February 26, 2004

RE: Yale Street Subdivision, Lots 2, 4, and 5

TITLE:
LOT 3
UNIVERSITY PARK
YALE STREET
BUILDING SITE LAYOUT

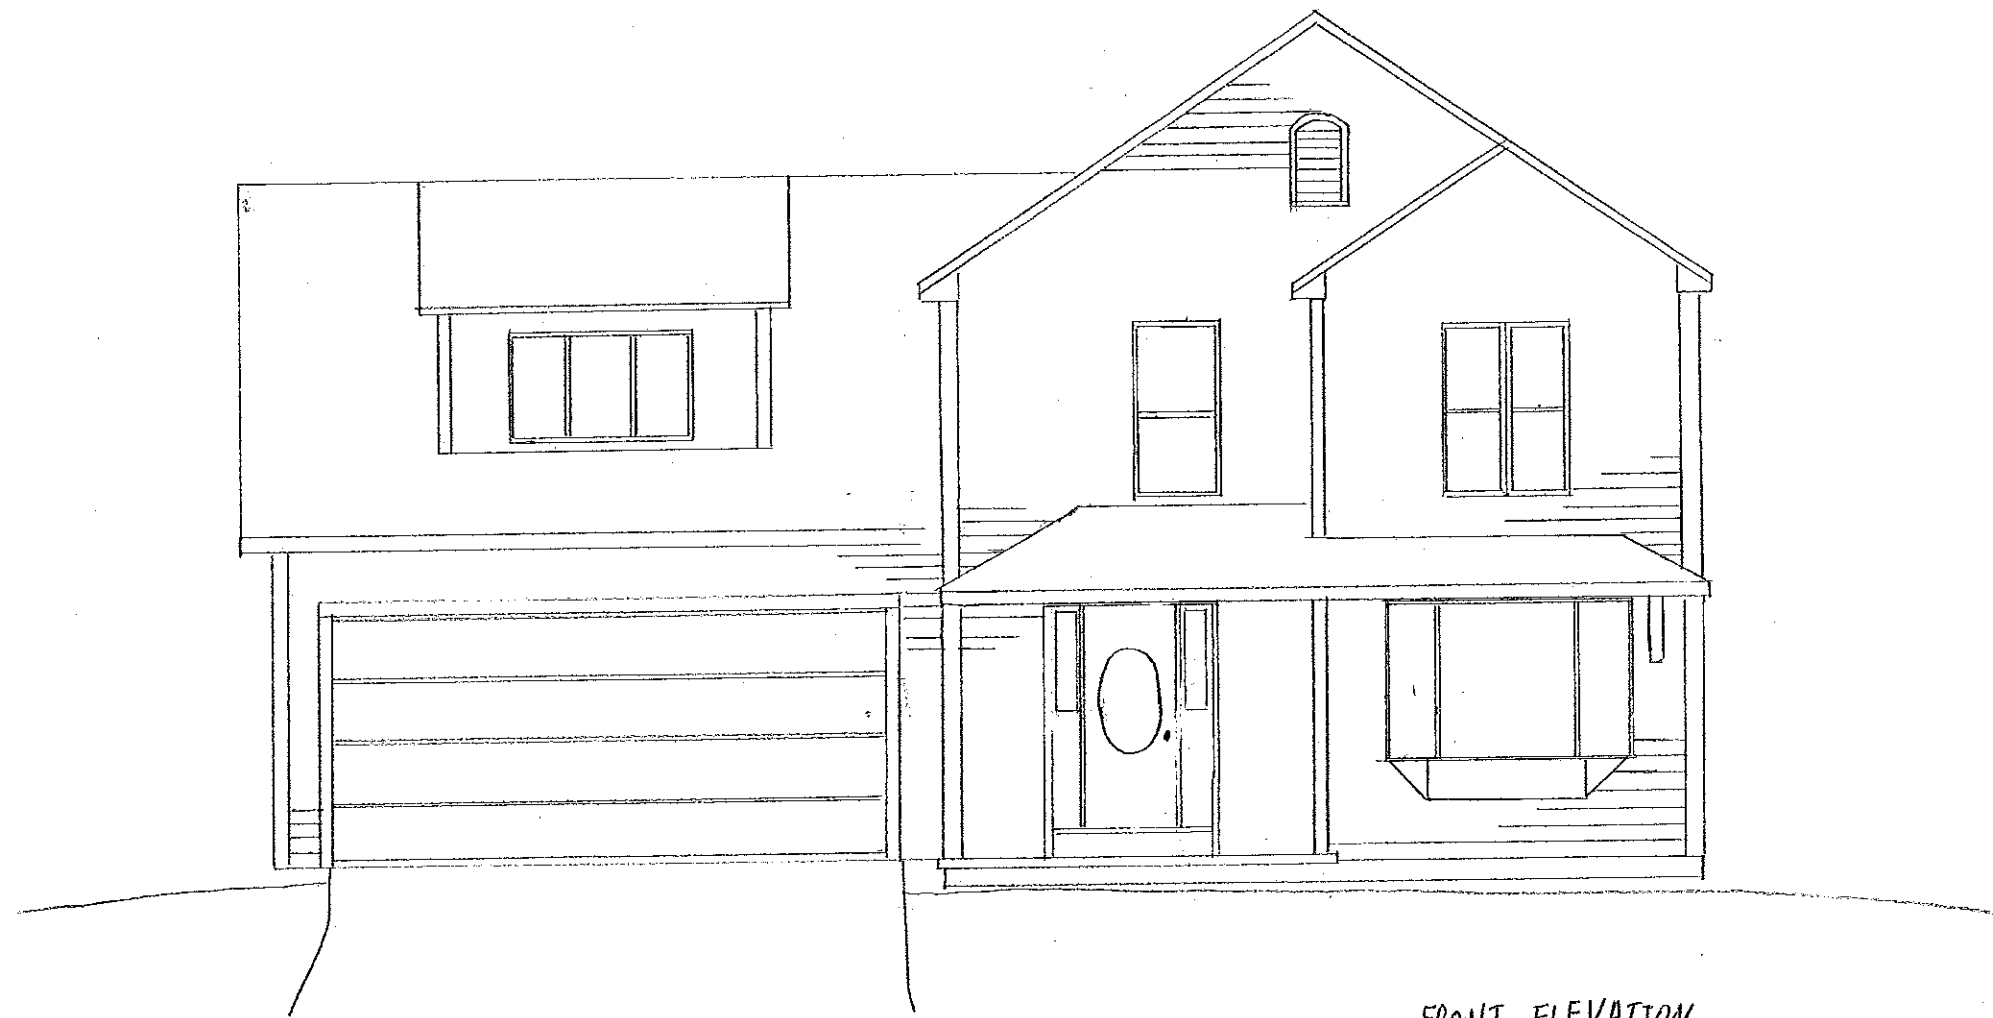
Currently lot 4's building permit application shows the same, building plans that do not match the grading/site plan. As I understand, you will be re-submitting to address this lot as well.
